WELWYN HATFIELD BOROUGH COUNCIL – DEVELOPMENT MANAGEMENT
DELEGATED REPORT

APPLICATION No: S6/2014/1366/FP

SITE ADDRESS: 391 St Albans Road West, Hatfield

DESCRIPTION OF DEVELOPMENT: Roof alterations and rear dormer

Drg.No: AT502-13A

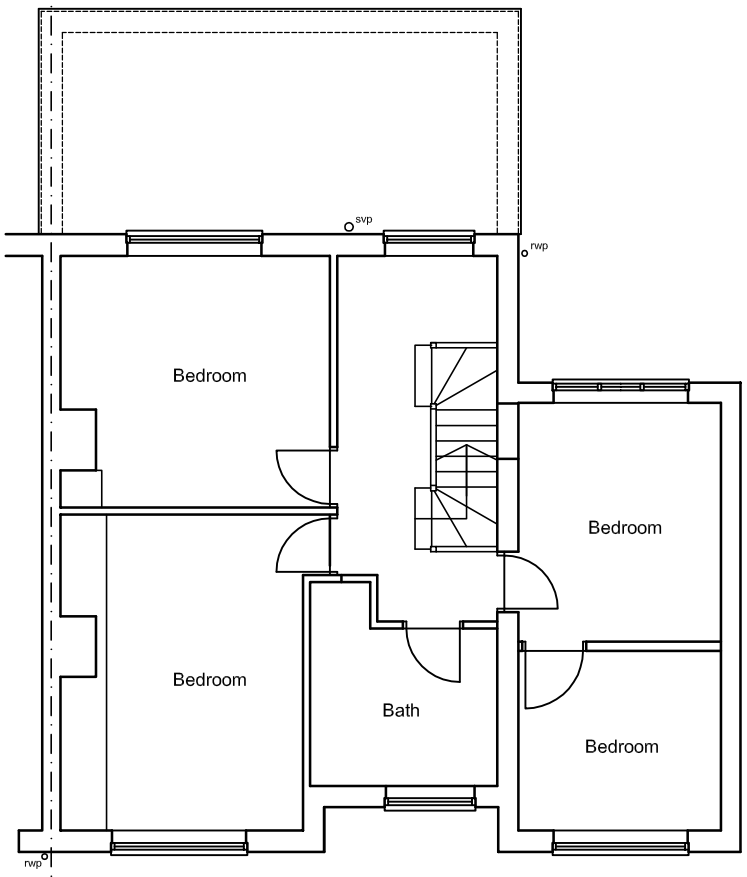
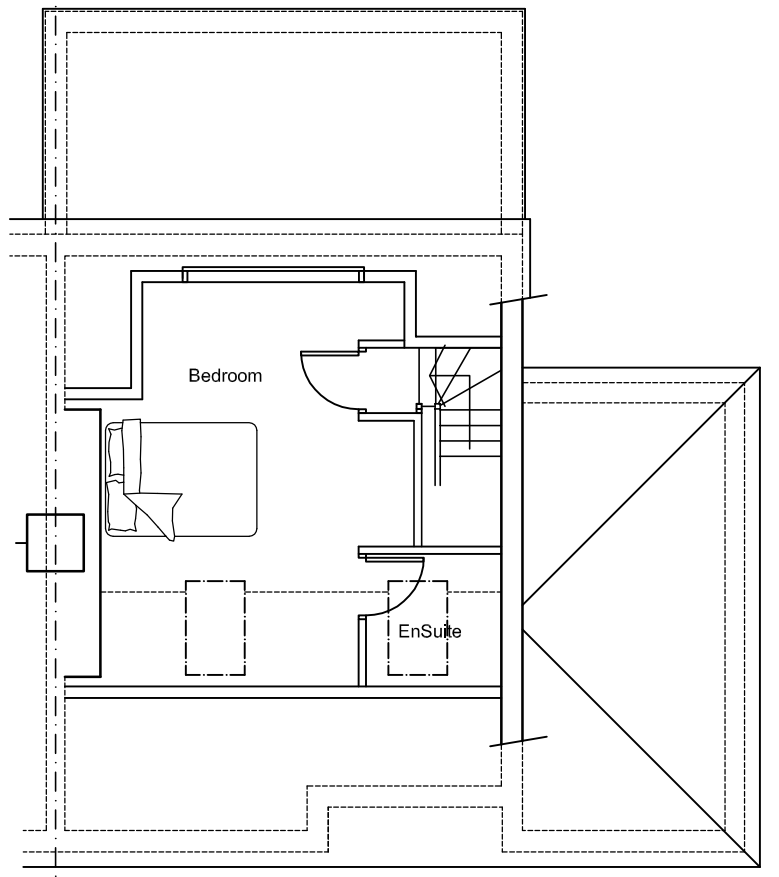
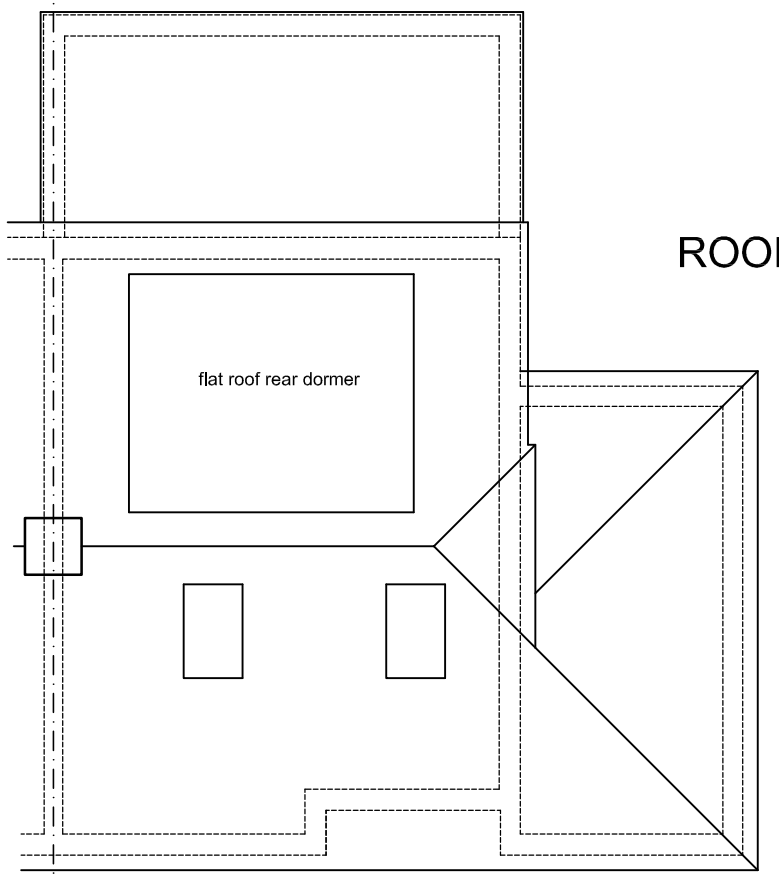
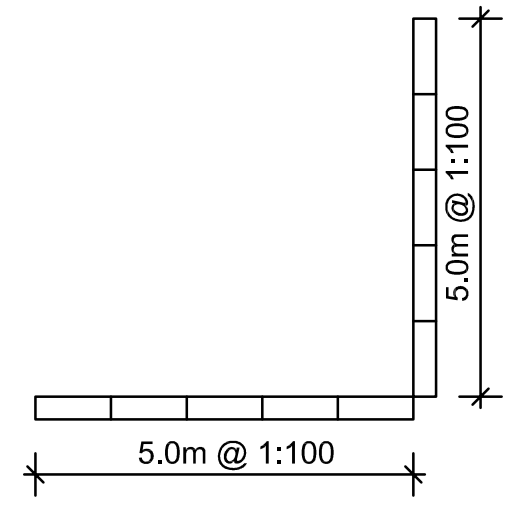
Notwithstanding the above, initial concerns were raised regarding the overall build and form of the rear dormer window, as it was considered to be excessive in scale. However, amended plans have been received which demonstrate that this element of the proposal has been reduced in scale. There would now be in excess of 1m from the side elevations of the dormer window to the flank elevations of the application property and approximately 0.6m from the base of this dormer window to the eaves of the existing dwelling. Taking all of the above into account it is considered that the dormer window would be subordinate in form and, as views of the rear dormer would be restricted and materials to be used in the actual construction of the works would match those of the existing dwelling, the proposal would not disrupt the design and character of the host dwelling to the extent that would warrant a refusal of permission. Having regard to the above, it is also considered that the proposal would not disrupt the character and appearance of the immediate streetscene and the visual interests of its surroundings.

Drg.No: AT502-14

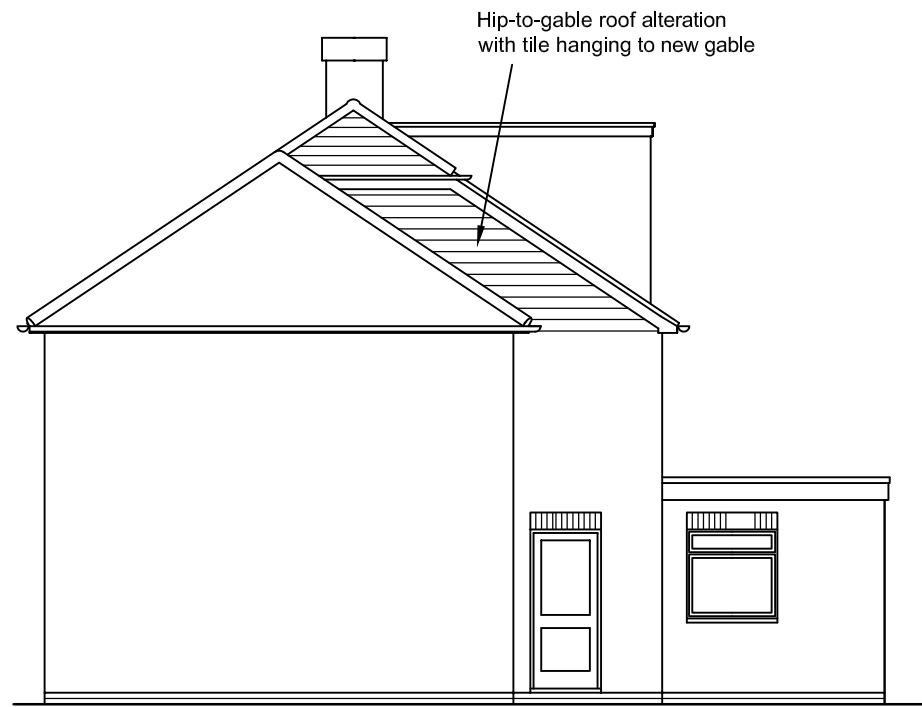
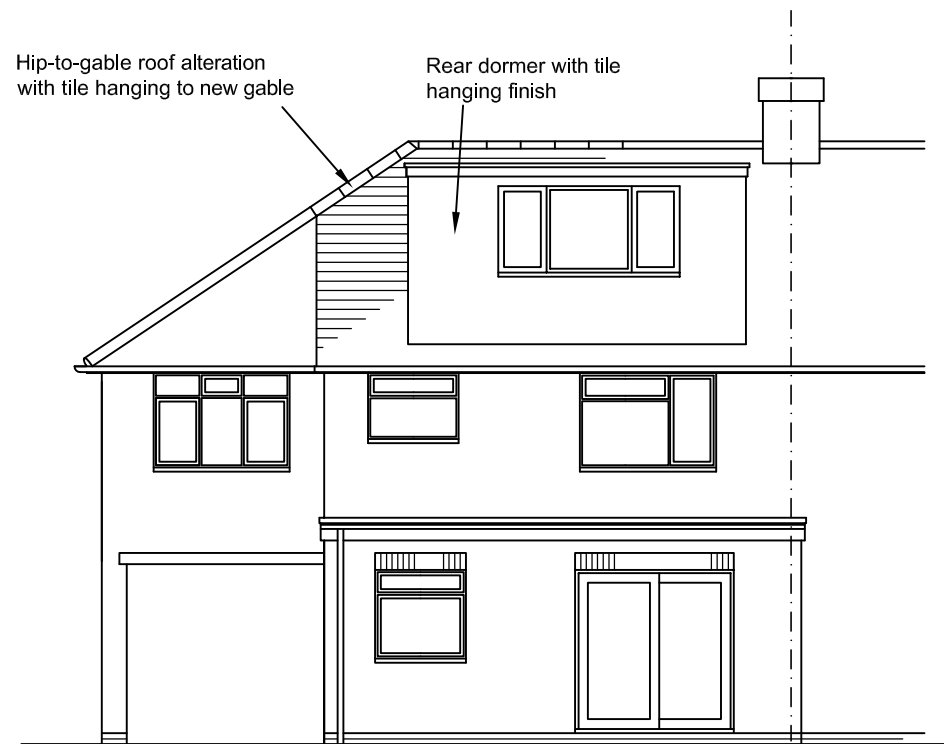
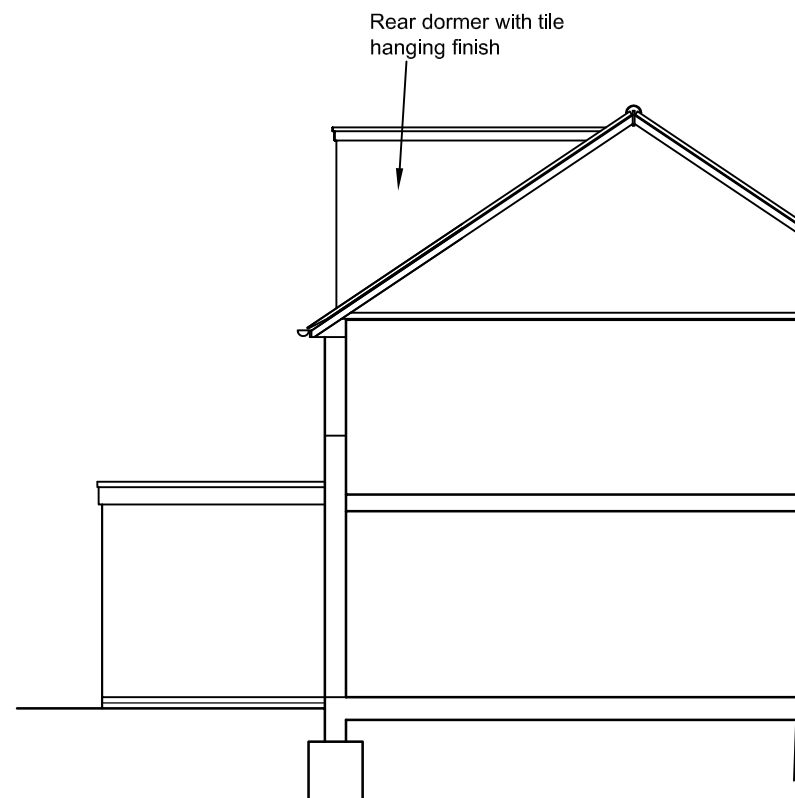
This application seeks full planning permission to increase the overall height of the roof to incorporate a loft conversion and rear dormer. The roof height would be increased to 7.7m, in line with the ridge height of the existing dwelling, and the dormer window to the rear would have a width of approximately 3.9m and a maximum height above ground level of approximately 7.7m.

Given the nature of the alterations to the roof, views would be available of the aspect of the development from the public domain. Views of the dormer window to the rear, however, would be restricted. Though the increase in roof height would not be subordinate in nature, it is considered that the roof alterations would rationalise the existing roof ridge and would aid in restoring the 'sense of balance' the host dwelling shares with the adjoining property. Additionally, the amount of roof space raised would not increase the overall bulk of the existing dwelling to the extent that the property appeared visually dominant within the established streetscene.
